City of Albuquerque Stormwater Construction Site Inspection Report

| ESC File No. | G11E069 | | Project Name: | Coors Pavilion | |
| COA Inspector | Doug Hughes | | Start/End Time: | 12:30-1:30 PM | |

**Erosion Sediment Control Plan**

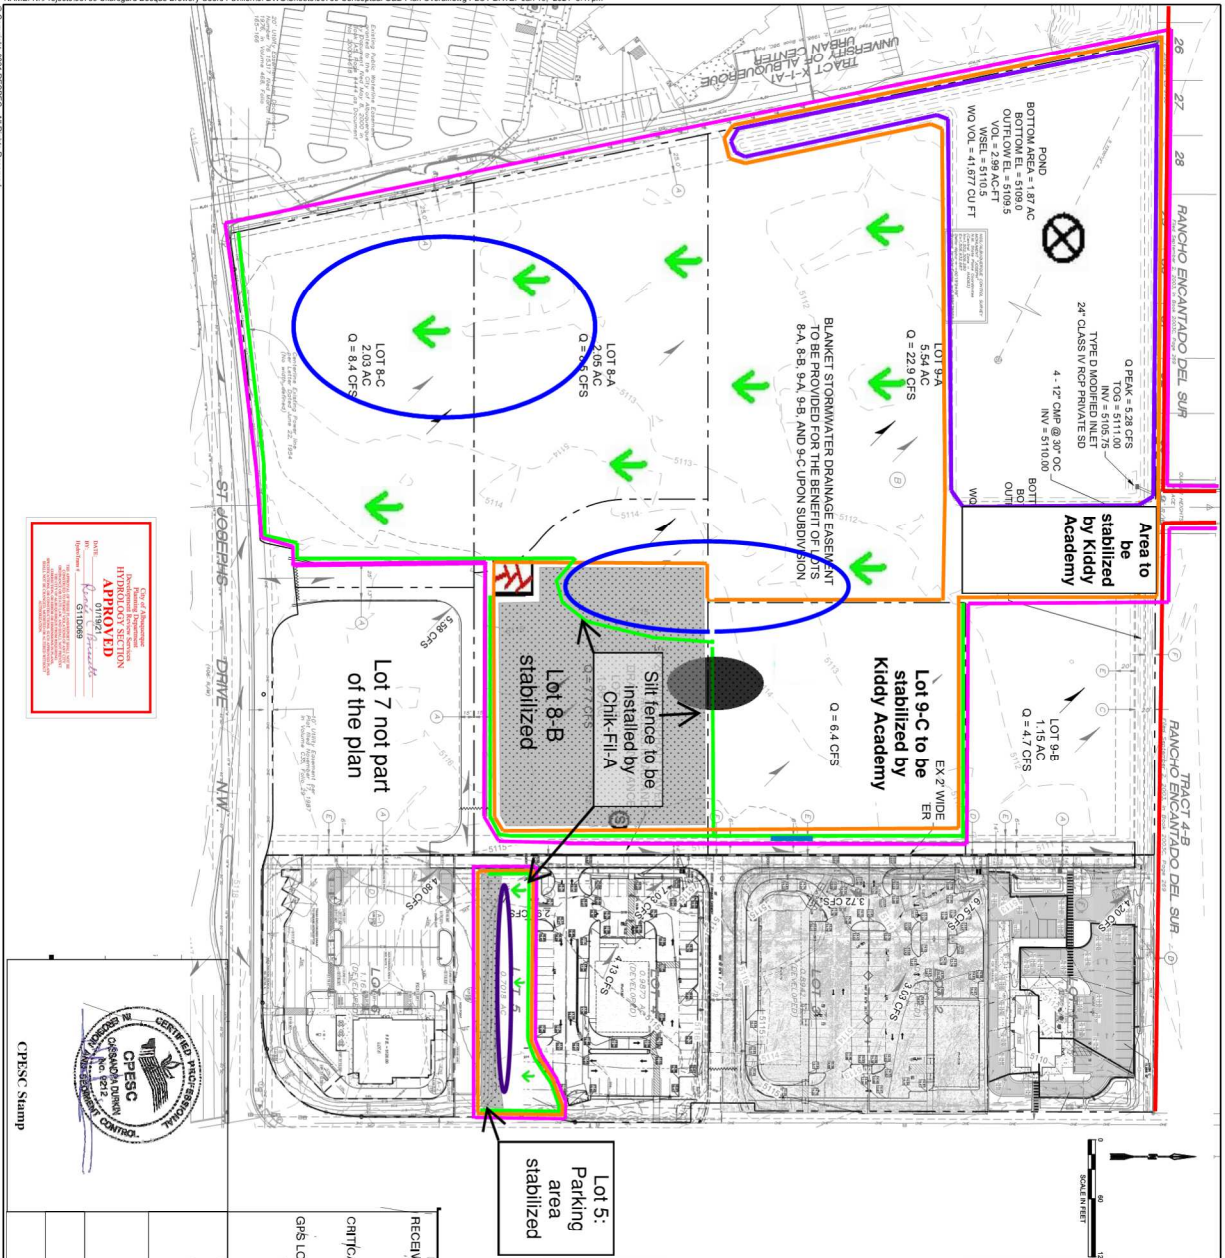
| ESC File No. | G11E069 | | Project Name: | Coors Pavilion | |
|--|---|-------------|-------------------------|-------------------|-----------|
| 1 | Recent land disturbing activity has been conducted without coverage under the EPA's CGP and without City approval. Lots 8C and 9C are covered by mostly bare dirt. There are also two stockpiles of dirt west of there. The property owner must obtain CGP coverage from the EPA by filing a Noitice of Intent NOI with the EPA. Then the NOI and ESC Plan must be submitted to the City of Albuquerque for review and approval | | | | |
| 4 | BMPs - Silt fence was down and in need of repair and reset. Reset within 7 days per CGP 5.2.2 | | | | |
| 6 | Inactive areas were not stabilized. Comply with CGP 2.2.14 | | | | |
